3. Project # 1002556
05DRB-01636 Major-Vacation of Pub Right-of-Way

Subject: Project #1002556 (07EPC-30035, 08DRB-70469), Site Development Plan for Subdivision, Golf Course Rd.

BORDENAVE DESIGNS agent(s) for CALABACILLAS GROUP request(s) the above action(s) for portionS of Golf Course Road NW and Westside Boulevard NW adjacent to Tract(s) D & E, **PARADISE HEIGHTS, UNIT 1**, located in the southeast corner of GOLF COURSE RD NW AND WESTSIDE BLVD NW containing approximately 15.784 acre(s). (A-12)

10800 GOLF COURSE RD NW
SITE PLAN FOR SUBDIVISION PURPOSES

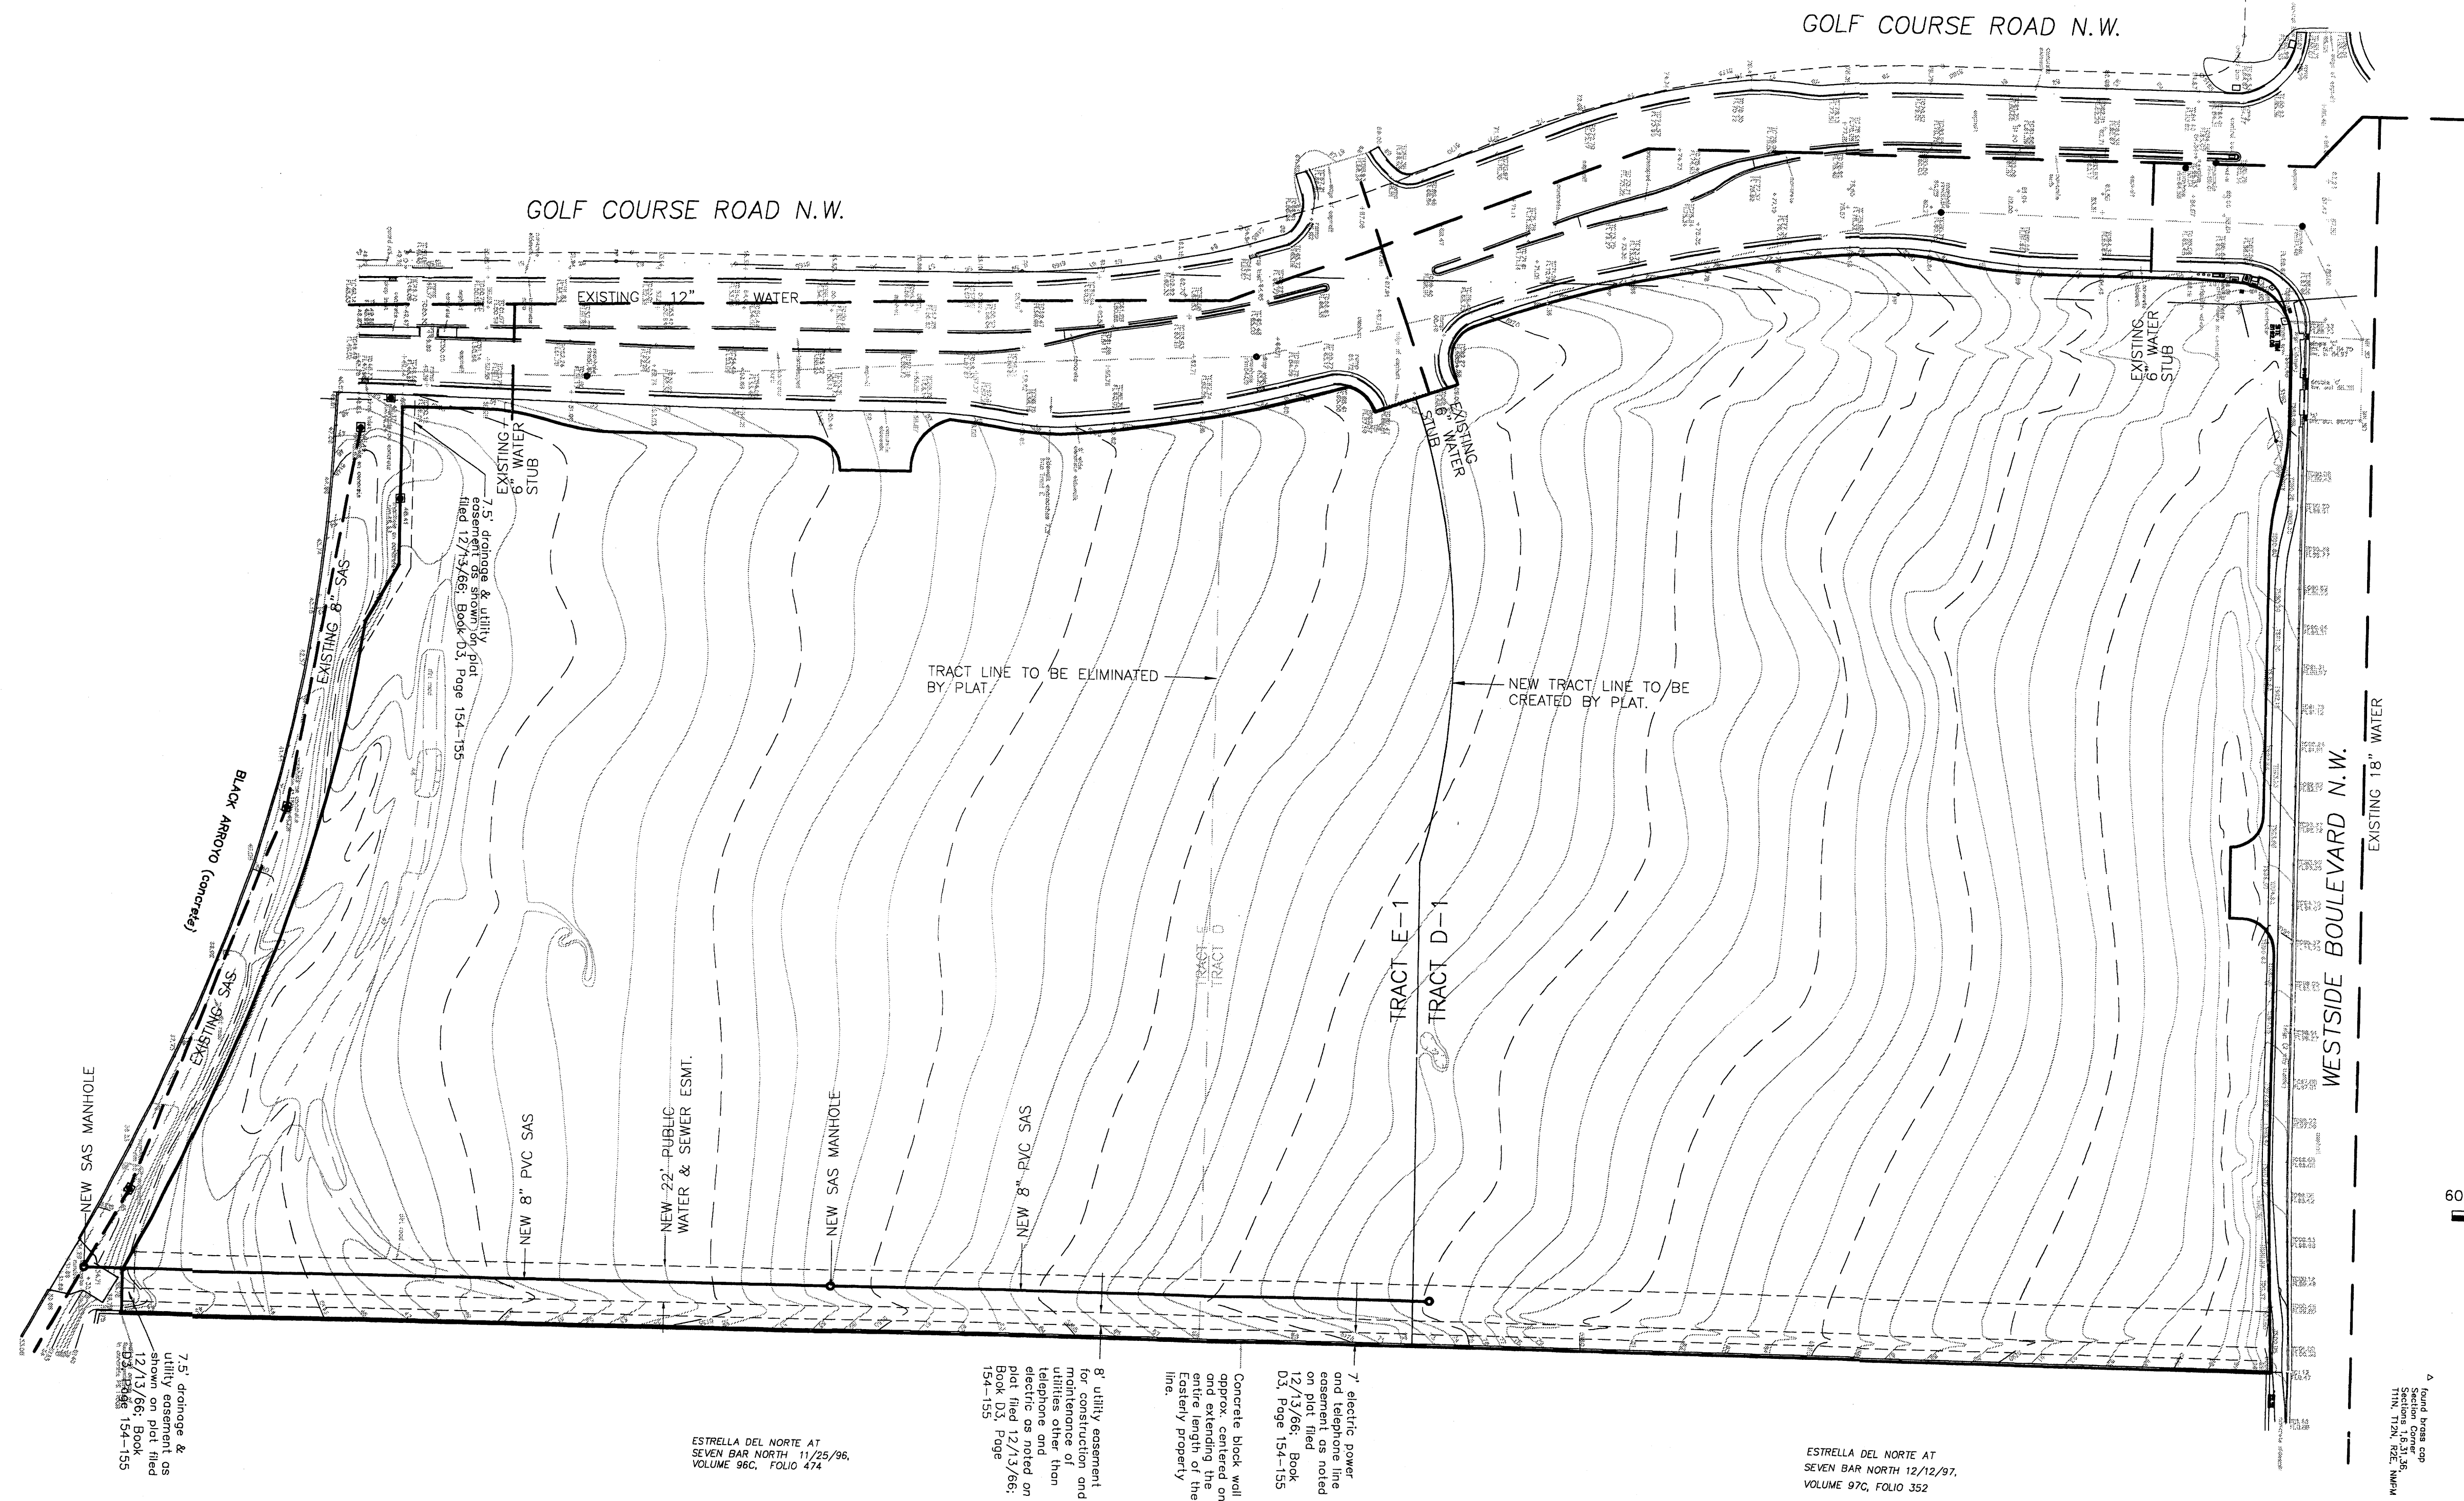
- # 5 - The applicant has not demonstrated that they have complied with the Air Quality Impact regulations of the Zoning Code.
- # 6 – Staff notes that under (b.) the deceleration lane on Westside Blvd. is not labeled “new” and that under (c), it is not clear which sidewalks are existing and to remain and which are proposed. Staff defers to the City Engineer for compliance with this condition.
- # 9 (d.) – Not all the species are listed in the appropriate plant categories.
- # 11 (c) – (i.) Minor correction: delete text “. Occupant...business” and merge the rest of the second sentence with the first sentence.
 - (ii) Move the new standard to the “Signs” section as # 5. Renumber the rest of the Subdivision Standards.

10800 GOLF COURSE RD NW
CONCEPTUAL UTILITY PLAN

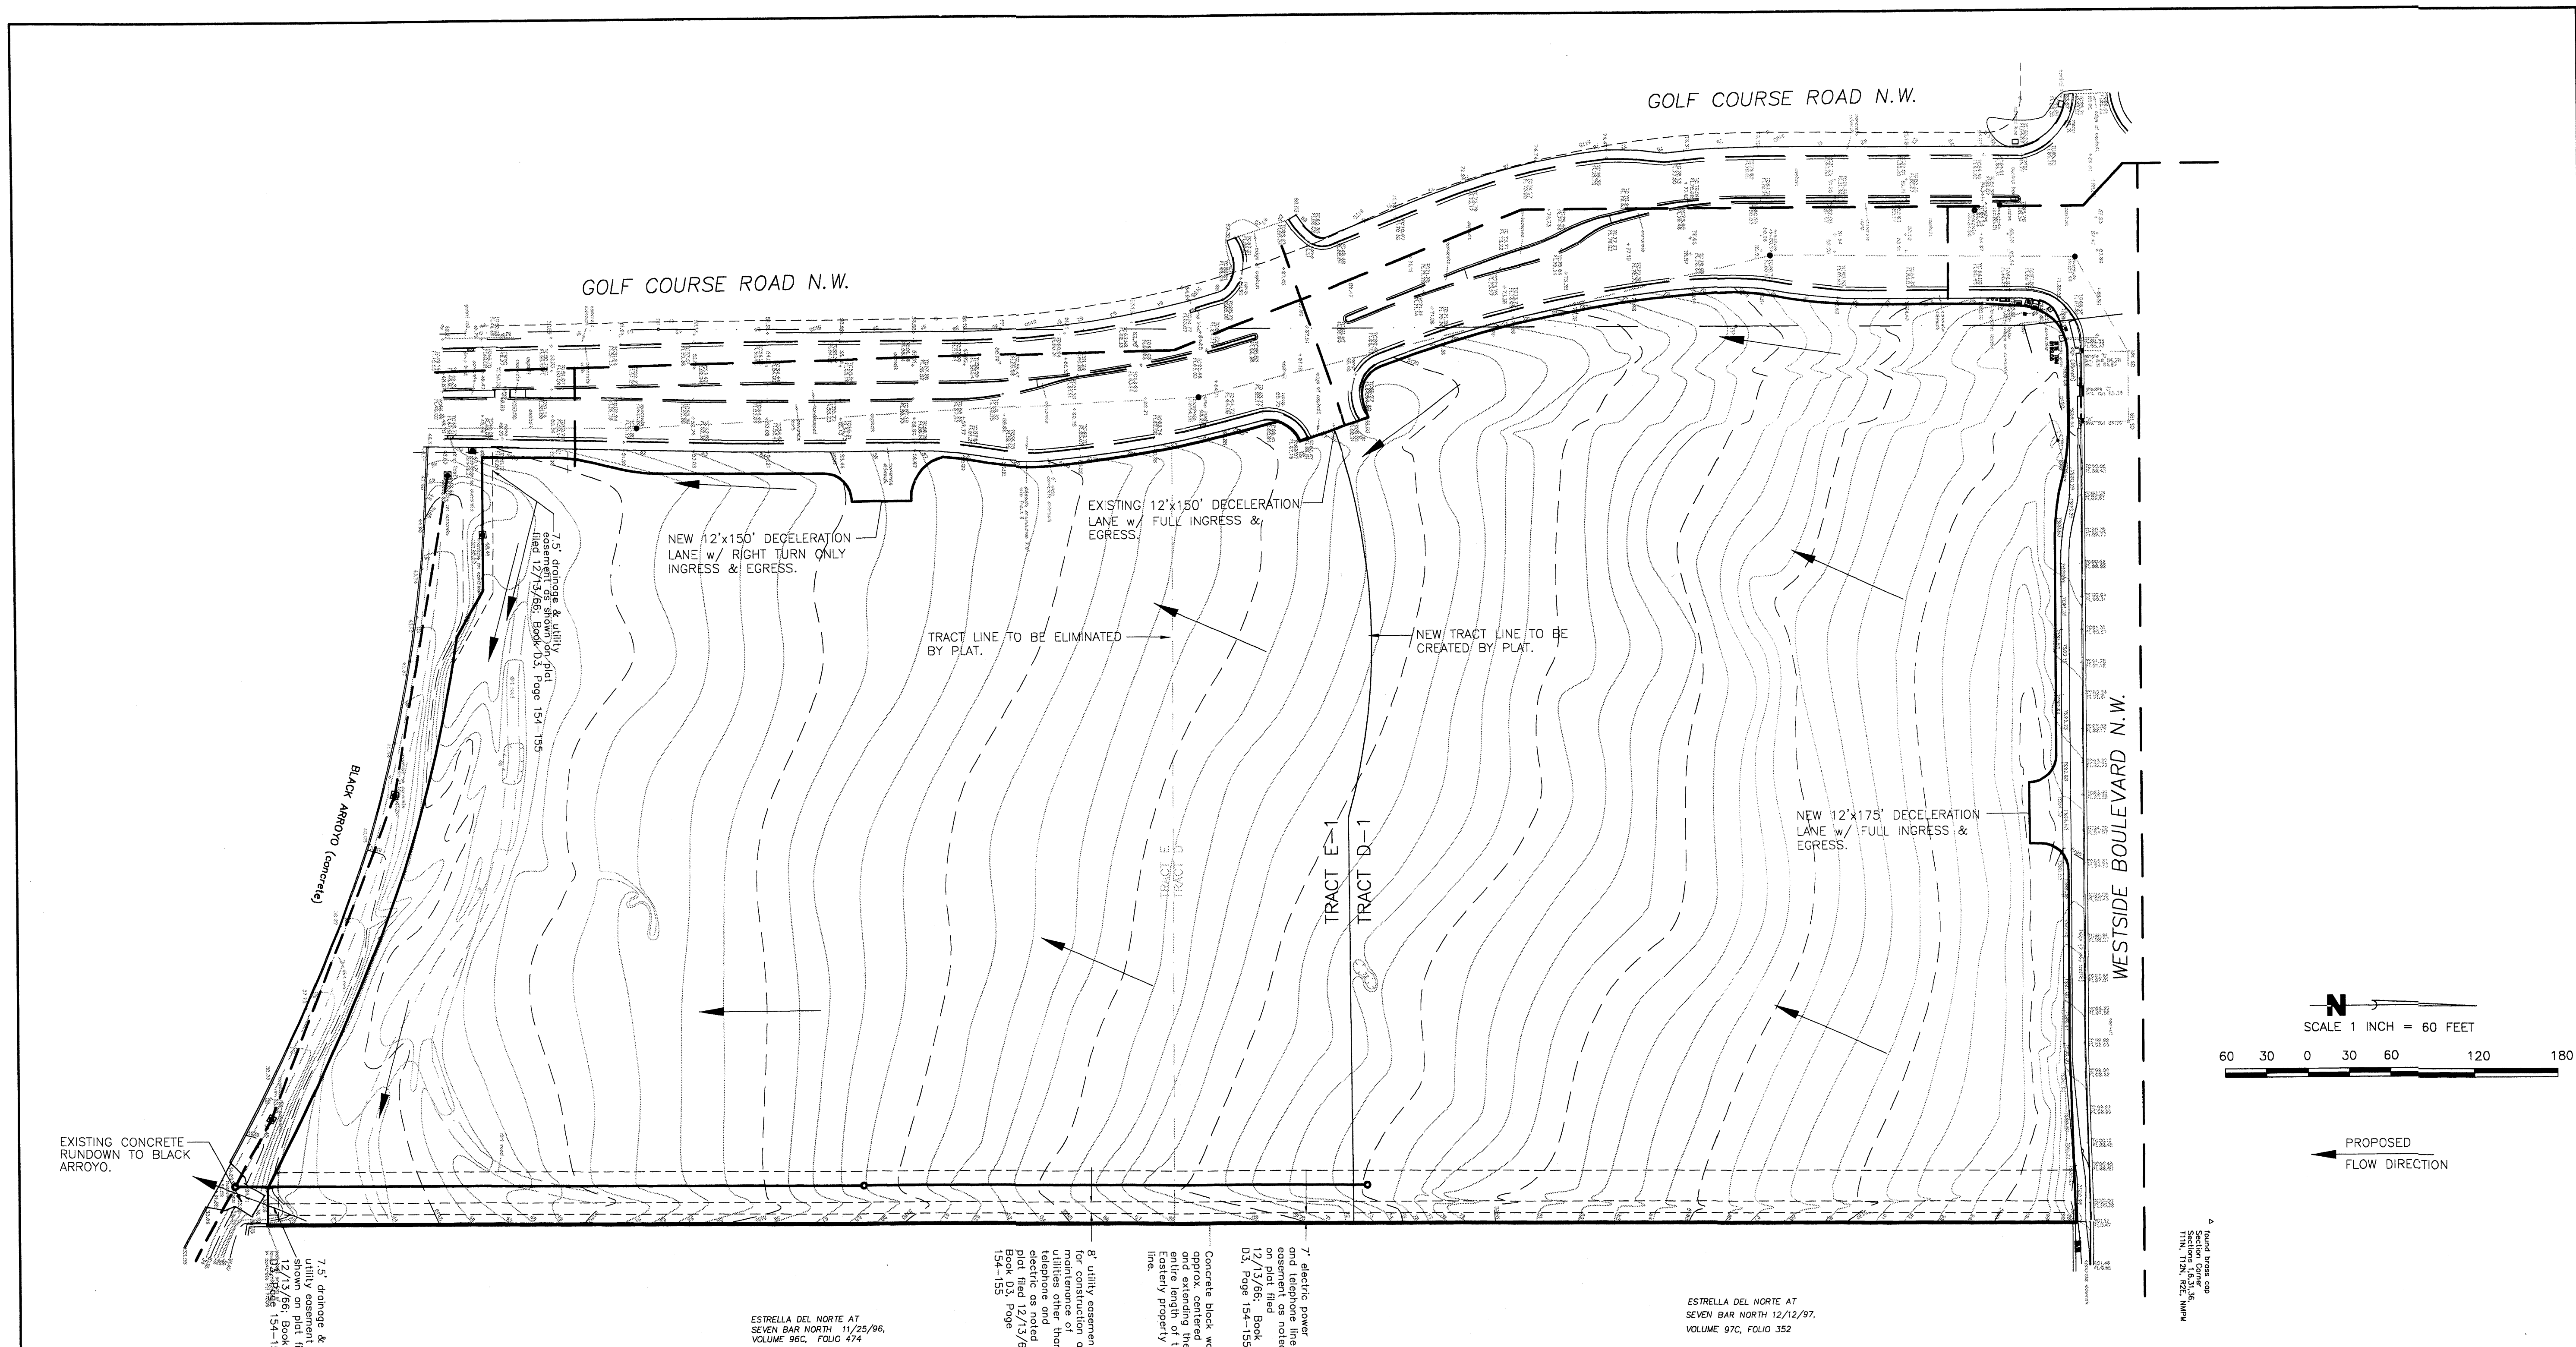
Staff also notes that the Grading & Drainage plan and the Utility plan are incomplete. Staff has contacted the applicant today about replacing them with those approved by the EPC.

VACATION EXHIBIT TRACTS D-I & E-I PARADISE HEIGHTS - UNIT I ALBUQUERQUE, NEW MEXICO MAY, 2008

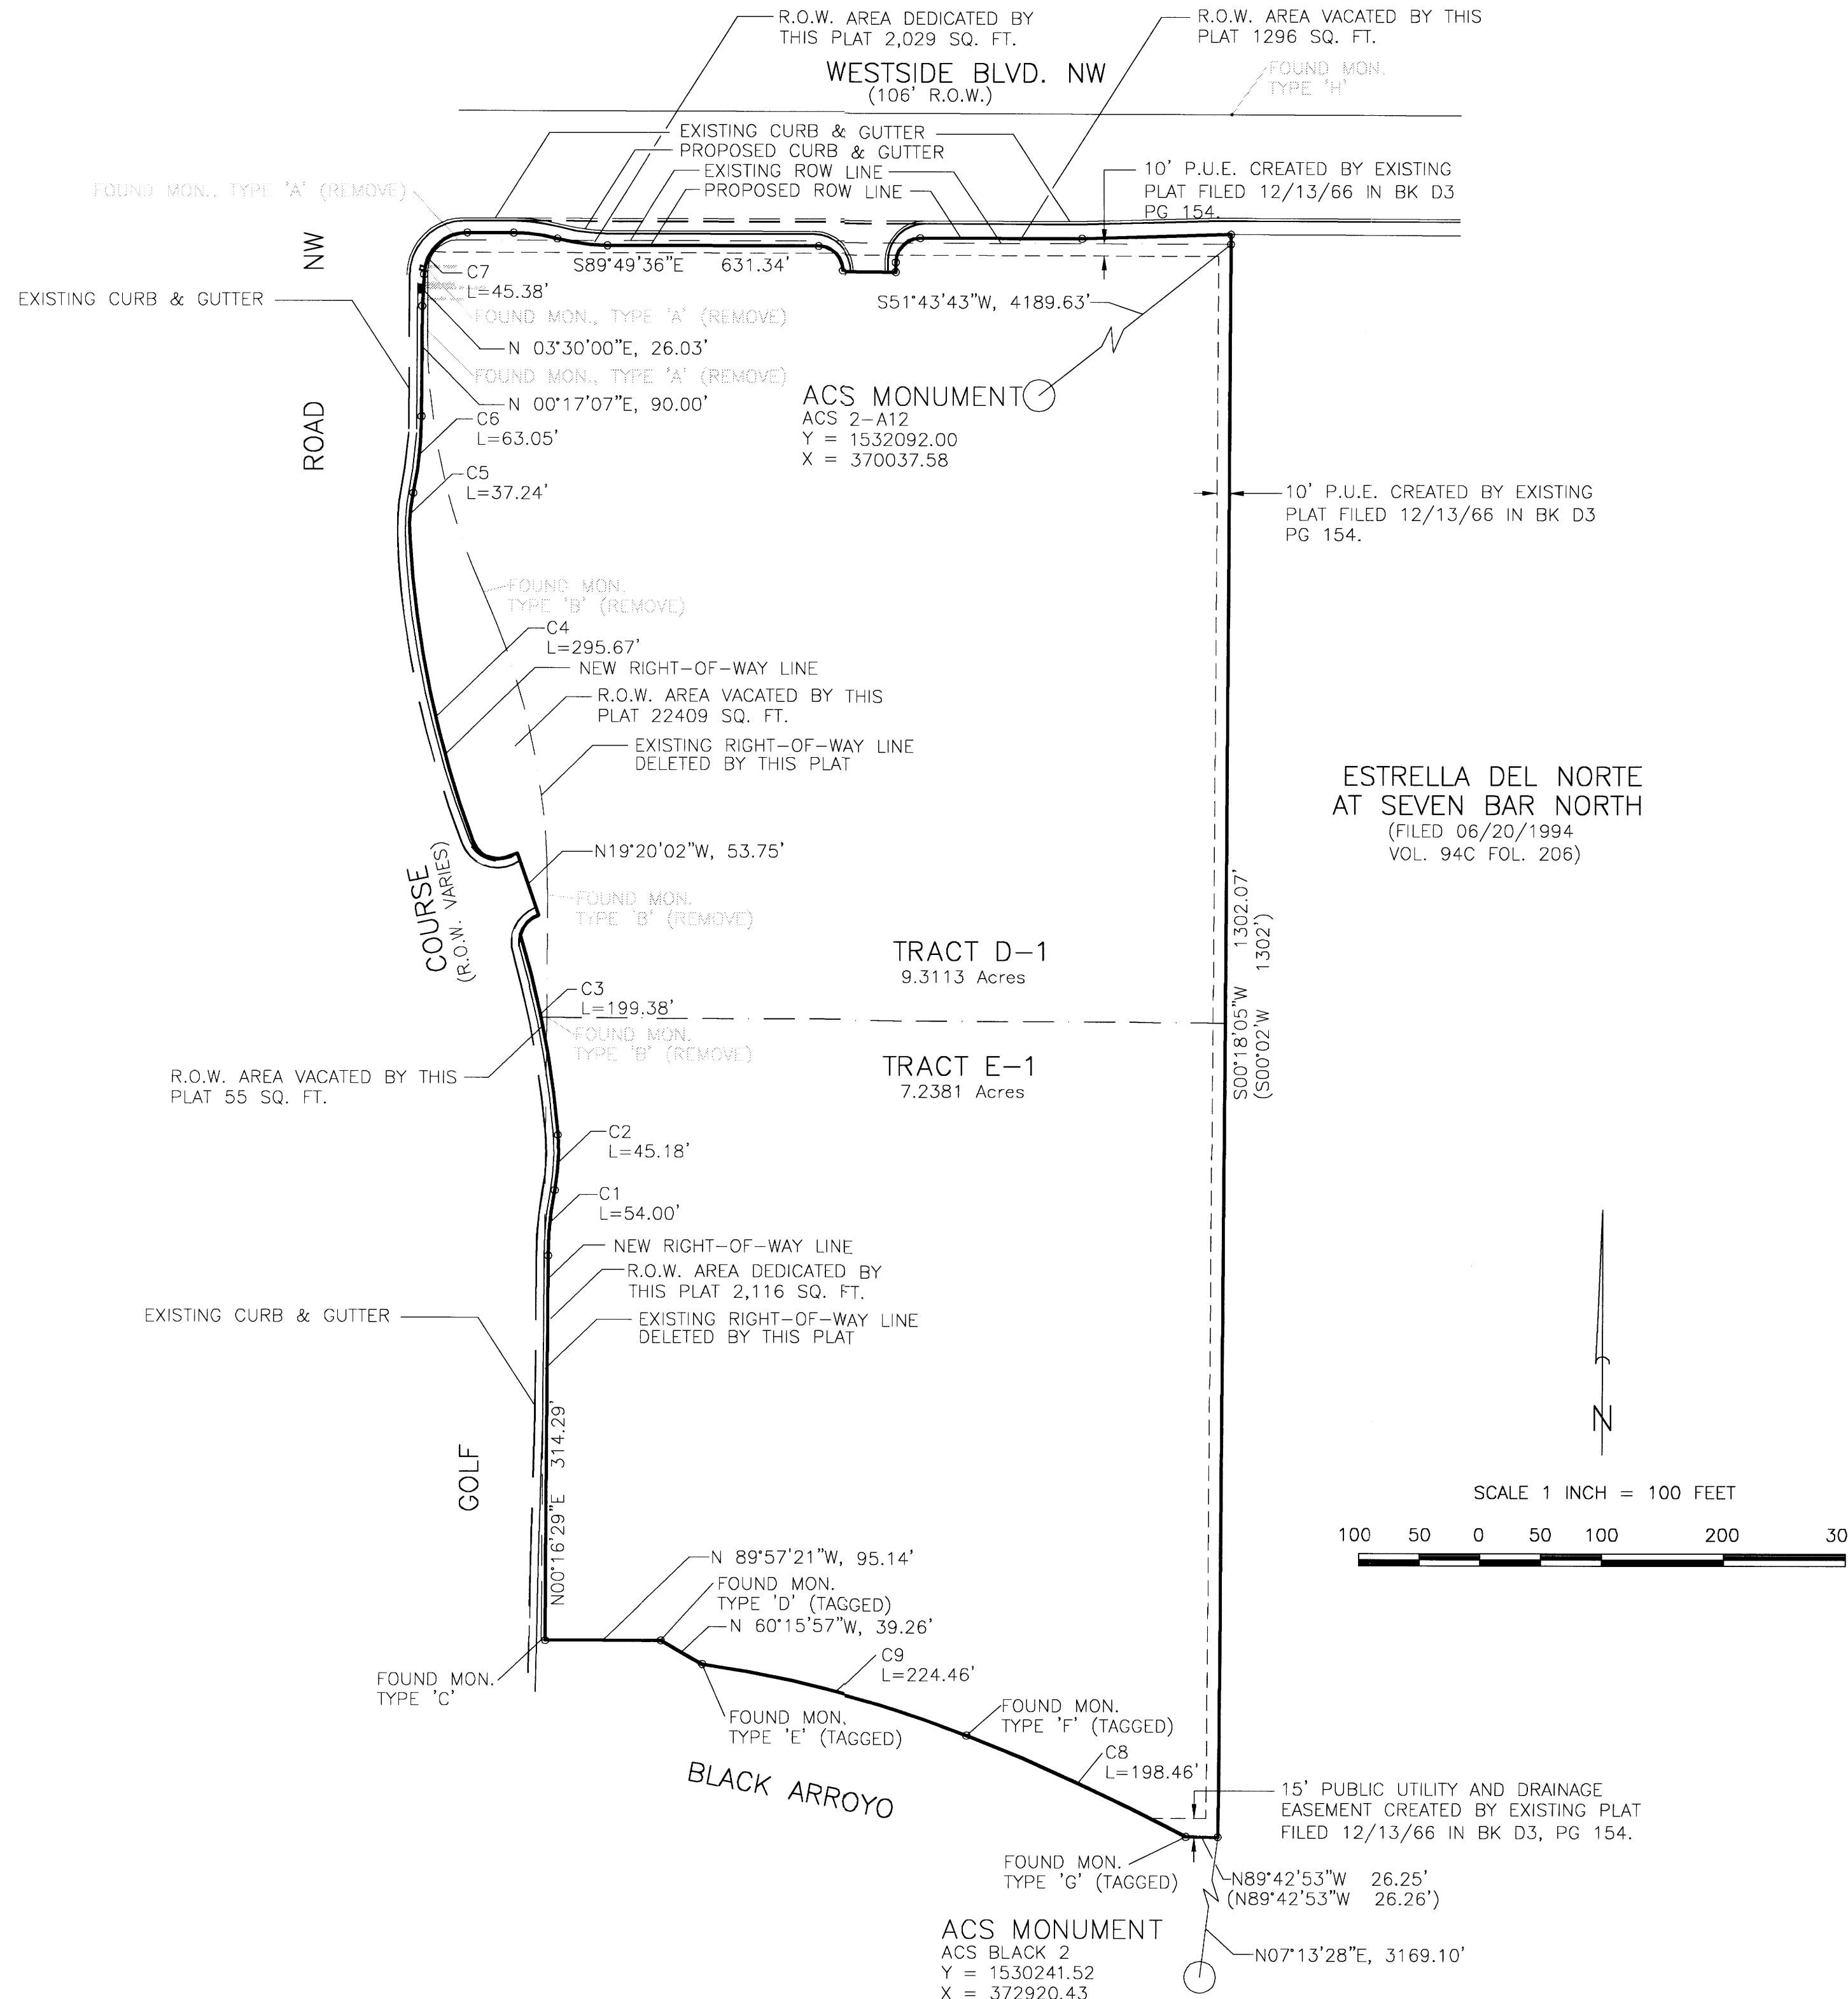
At the June 4, 2008 Development Review Board meeting, the vacation was approved as shown on Exhibit B in the Planning file per section 14-14-7-2(A)(1) and (B) (1)(3) of the Subdivision Ordinance subject to calling out the width of the right-of-way, indication of pavement location, and the distance of face of curb to the property line.

PNM ELECTRIC & GAS No comment.
COMCAST No comments received.
QWEST No comments received.
ENVIRONMENTAL HEALTH No comments received.
M.R.G.C.D No adverse comments.
OPEN SPACE DIVISION No adverse comments.
CITY ENGINEER No objection to the vacation request.
TRANSPORTATION DEVELOPMENT The vacation exhibit must define the exact right of way width in this area. In addition, provide an exhibit showing the location and width of all pavement, the location of sidewalk, and defining the distance from face of curb to the property line.
PARKS AND RECREATION Defer to Transportaion.
ABCWUA No objection to Vacation request.
PLANNING DEPARTMENT Refer to comments from Transportation Development, Municipal Development and City Engineer regarding proposed vacation.
